Your Ref EN010132

Wednesday 28 February 2024

Re: Deadline 4 Response, West Burton Solar Project

Land Plans
Sheet 7 of 10

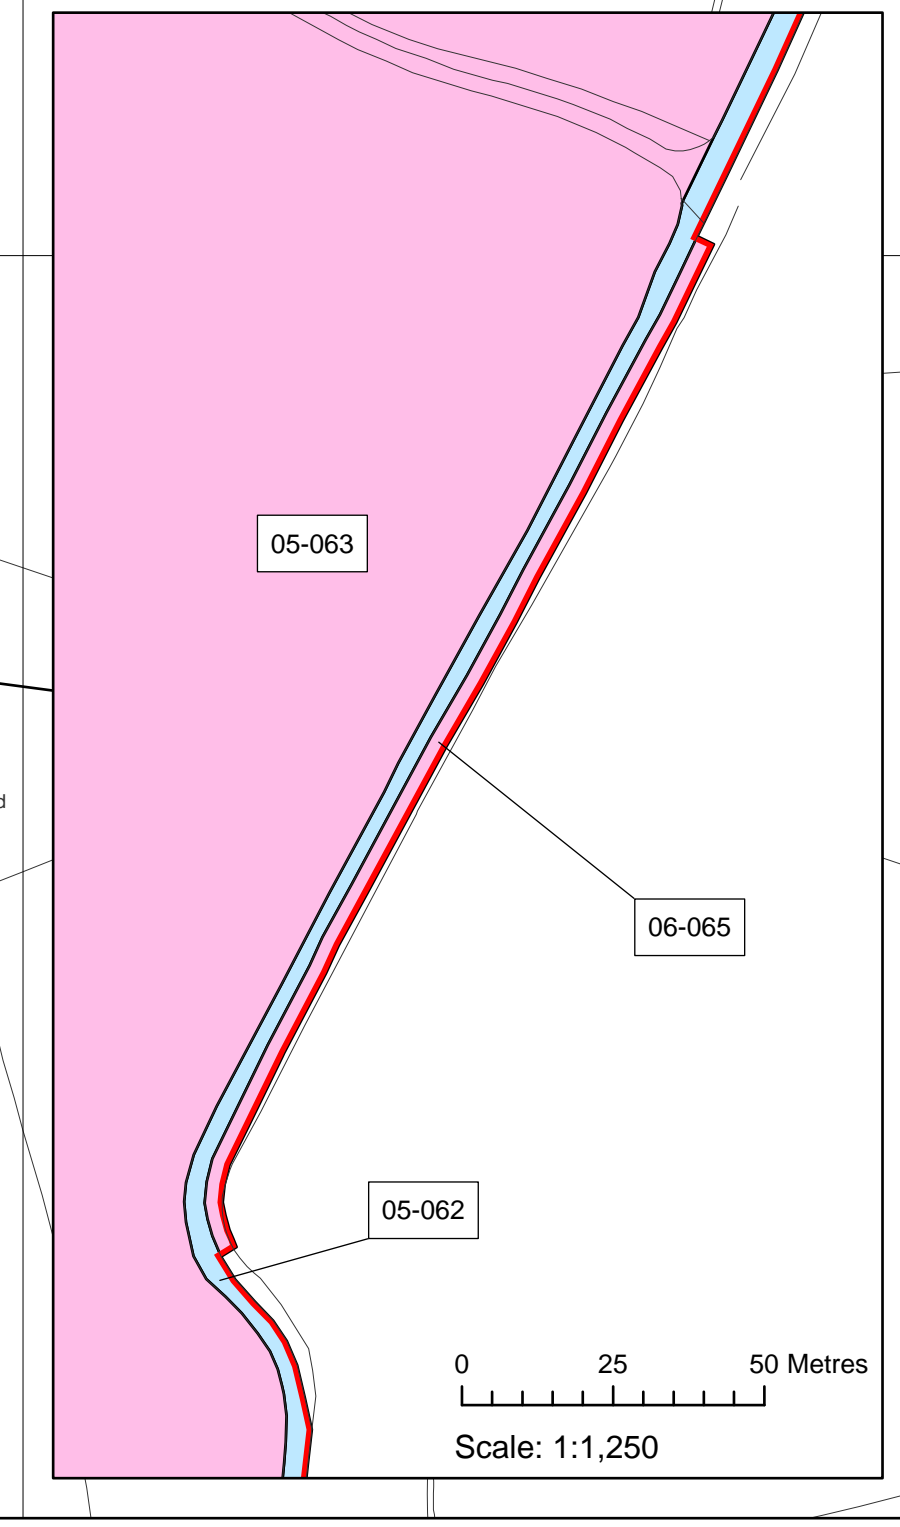
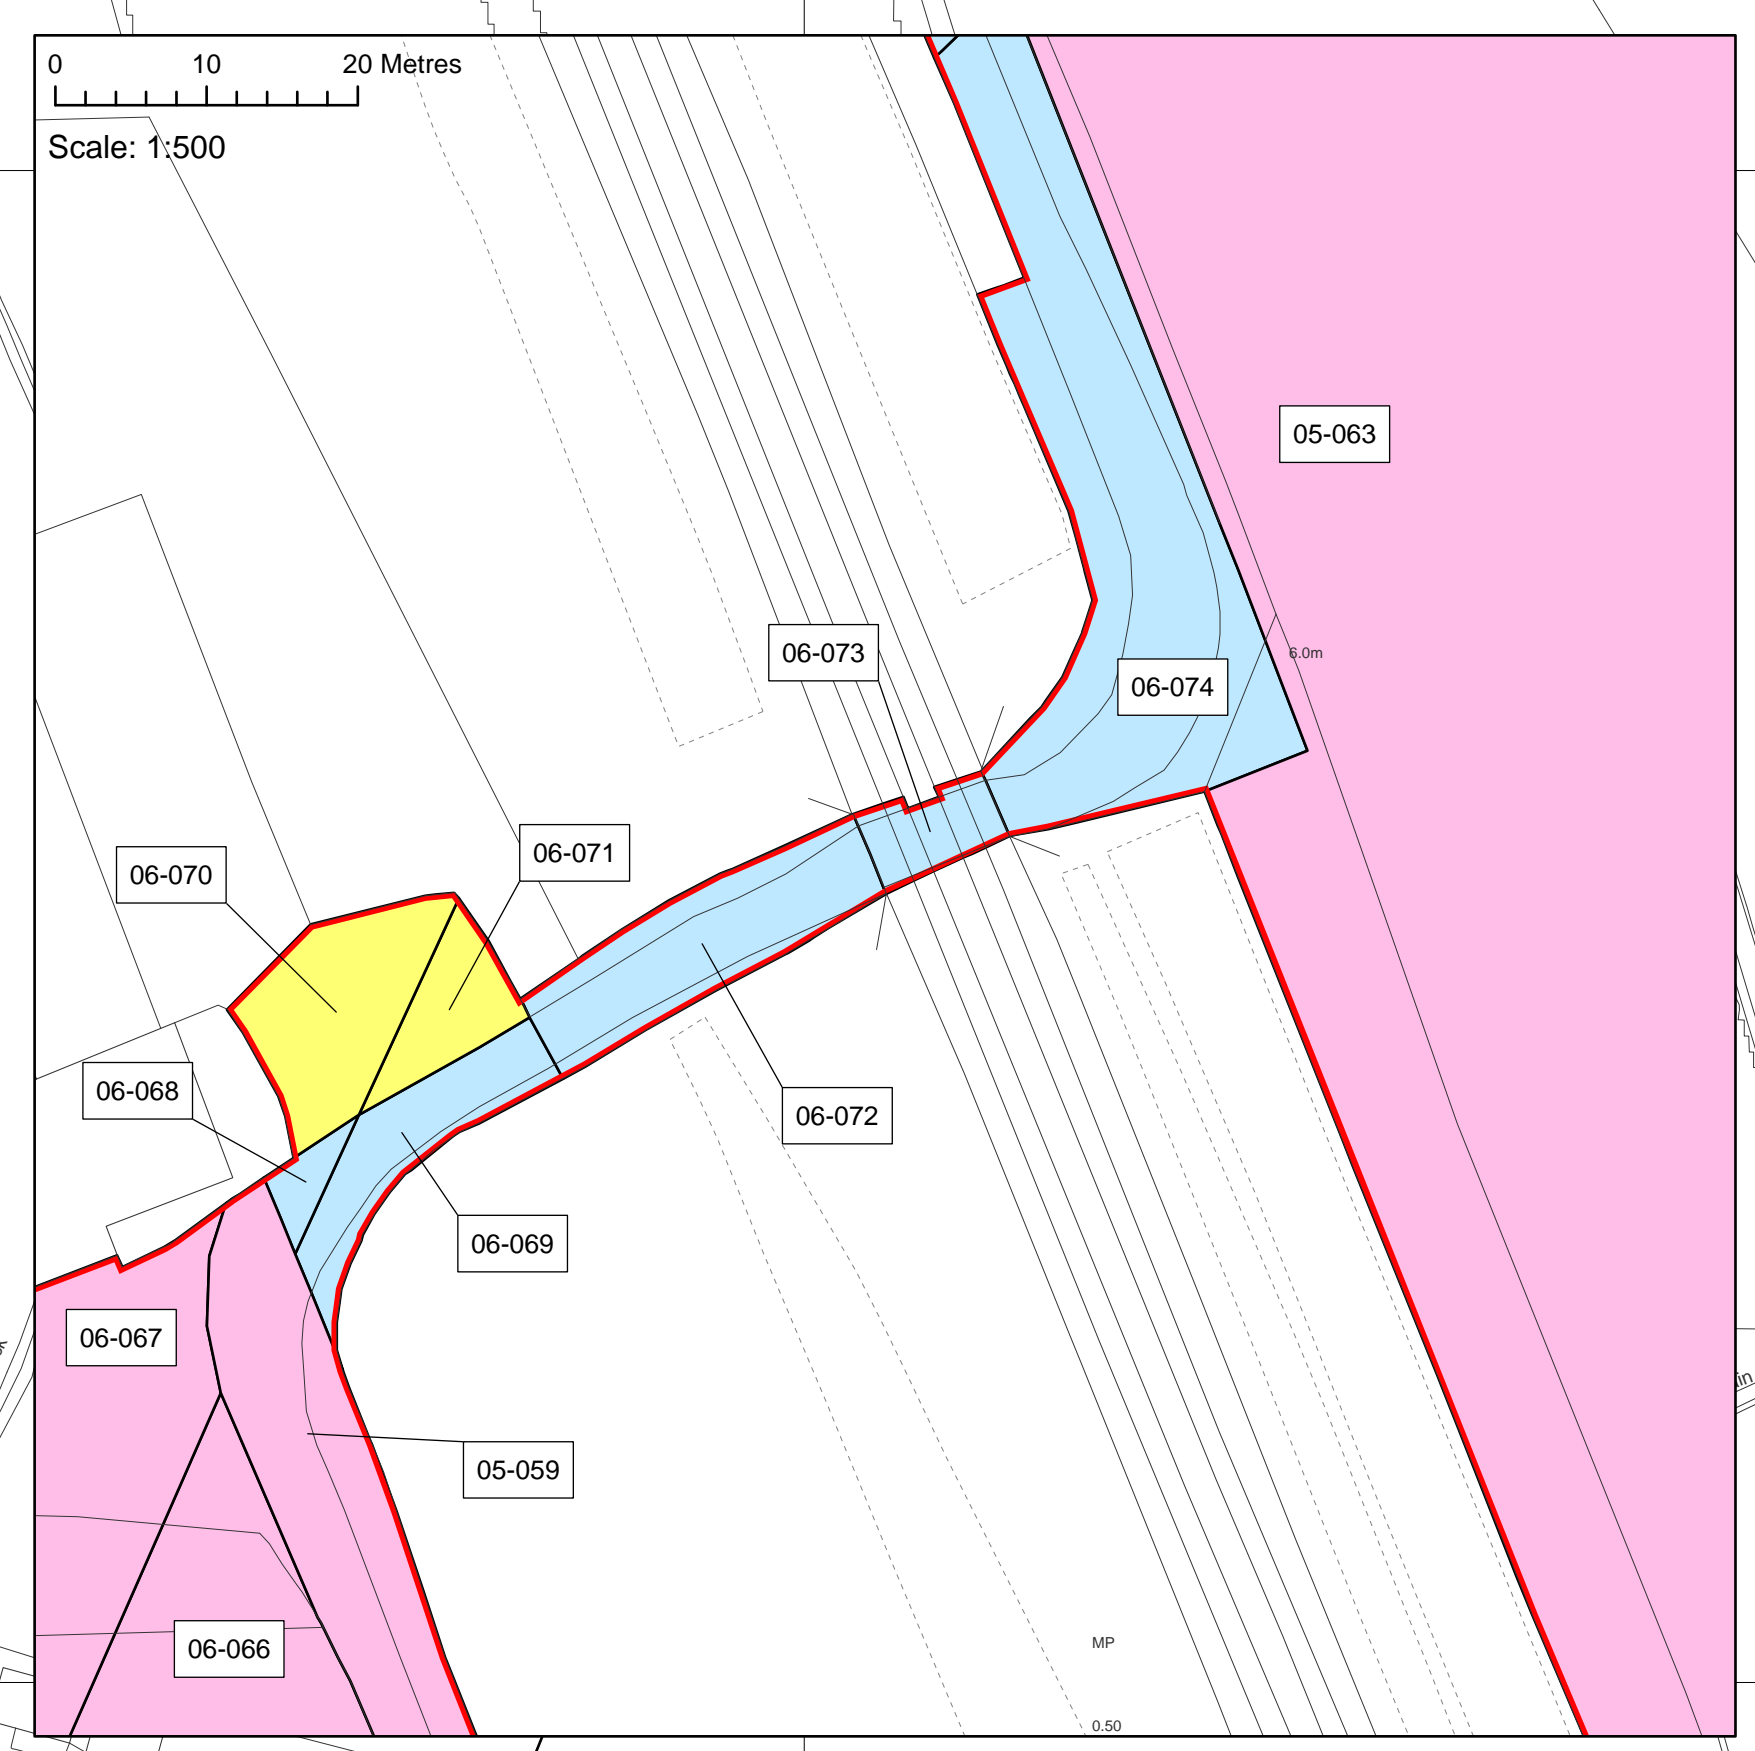
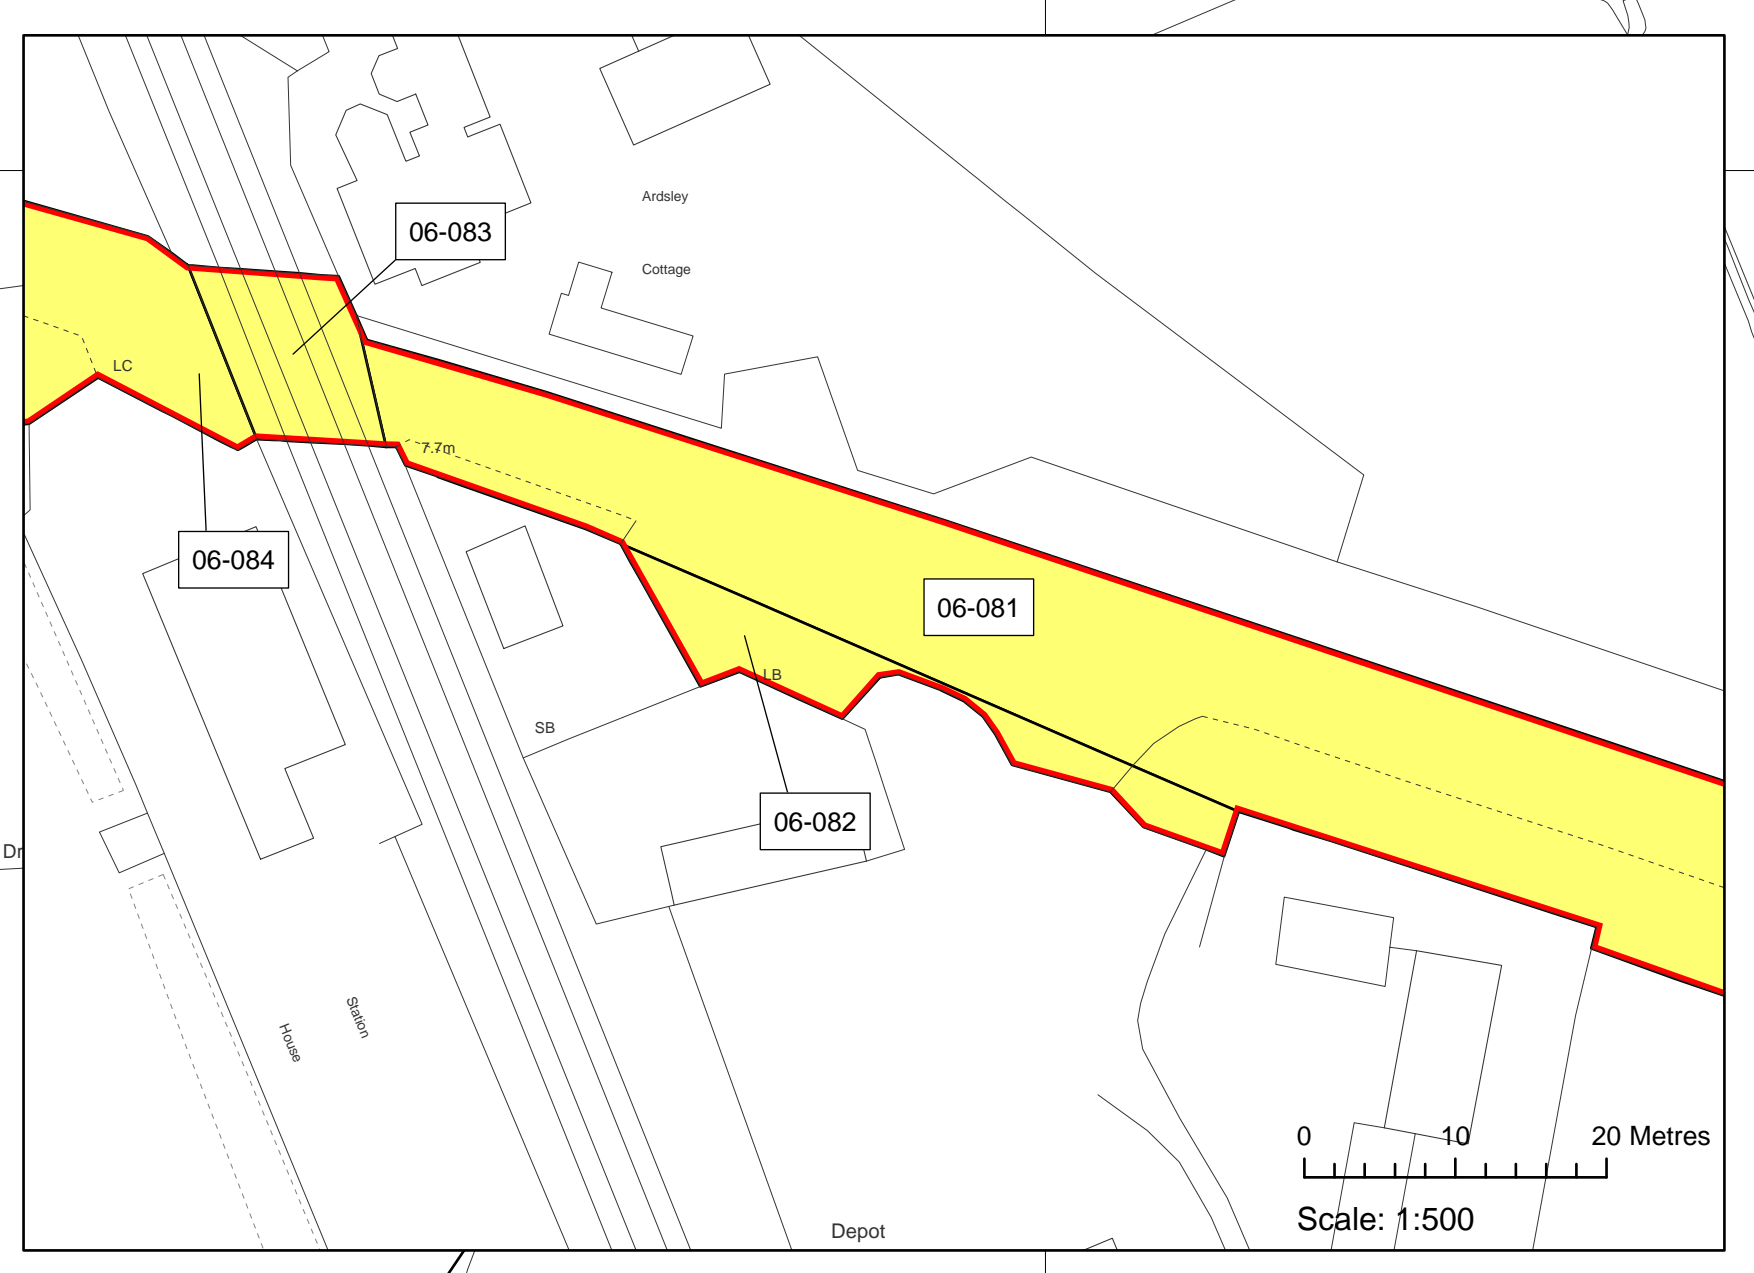
The parties continue to negotiate the agreement for the rights required for the project in respect of the cable route beneath the Trust's dredging tip (parcel 07-121). We are confident agreement will be reached prior to the end of the Examination.
